From: Amanda Scholes on behalf of Planning.Responses
Sent: 14 January 2021 11:51
To: Planning Scanning
Subject: FW: Croft Works Site Access Driveway R/197/20/OUT

Hi Adam,
I acknowledge receipt of your e-mail and photos which will be added to the application and the additional information will be included in a Committee report update . Please can you provide a revised site plan /extract site plan to indicate the measurements you have noted?
Regards
Anita Gardner

From: Adam King <[REDACTED]>
Sent: 10 January 2021 20:22
To: Anita Gardner <Anita.Gardner@arun.gov.uk>
Subject: Croft Works Site Access Driveway

SITE PLAN 1:250

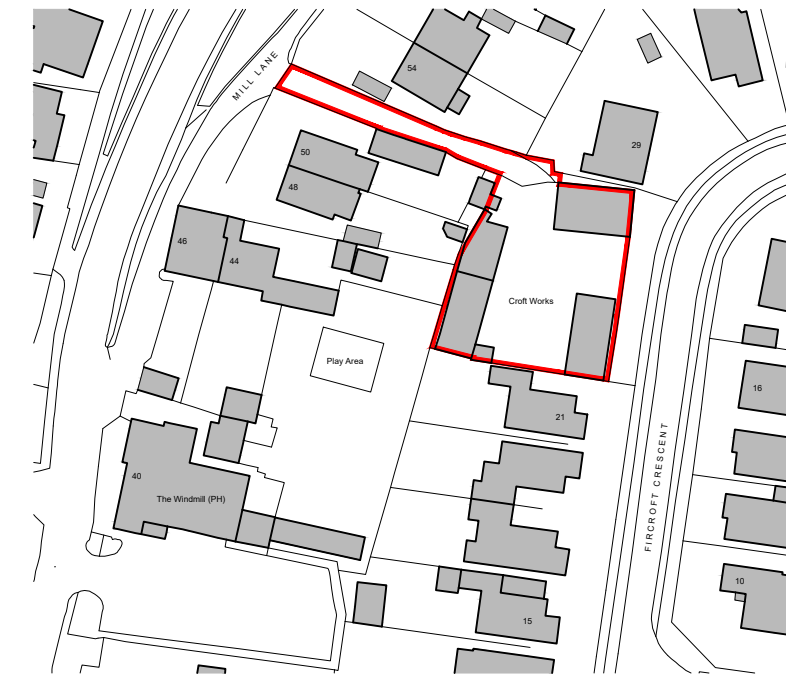
Hi Adam,
Please can you let me have the revised site/block plan details by lunchtime today?
Agenda close for February DC is the end of the week and I need to complete the update to the report and refer to amended drawing numbers before Friday.
Thanks

Broadly speaking, the width of the entrance point is very close to the noted 4.65m at around 4.5m, and there is the potential to revise the northern fence slightly to remove the concrete posts and renew the fence to a higher quality one. There is a pinch point at around the centre of the access driveway where this reduces to 3.3m wide. At the end of the driveway the dimension measures 3.85m to the timber post which is slightly less than the 4.1m on the title plan.

Unfortunately I've been homeschooling for the last few days so haven't had a chance to complete the drawing. Is it okay if you receive this later on today after lunchtime? The revision number will be the next revision after the current drawing and it will simply show the dimensions that were noted on my photographs that was sent a few days ago.
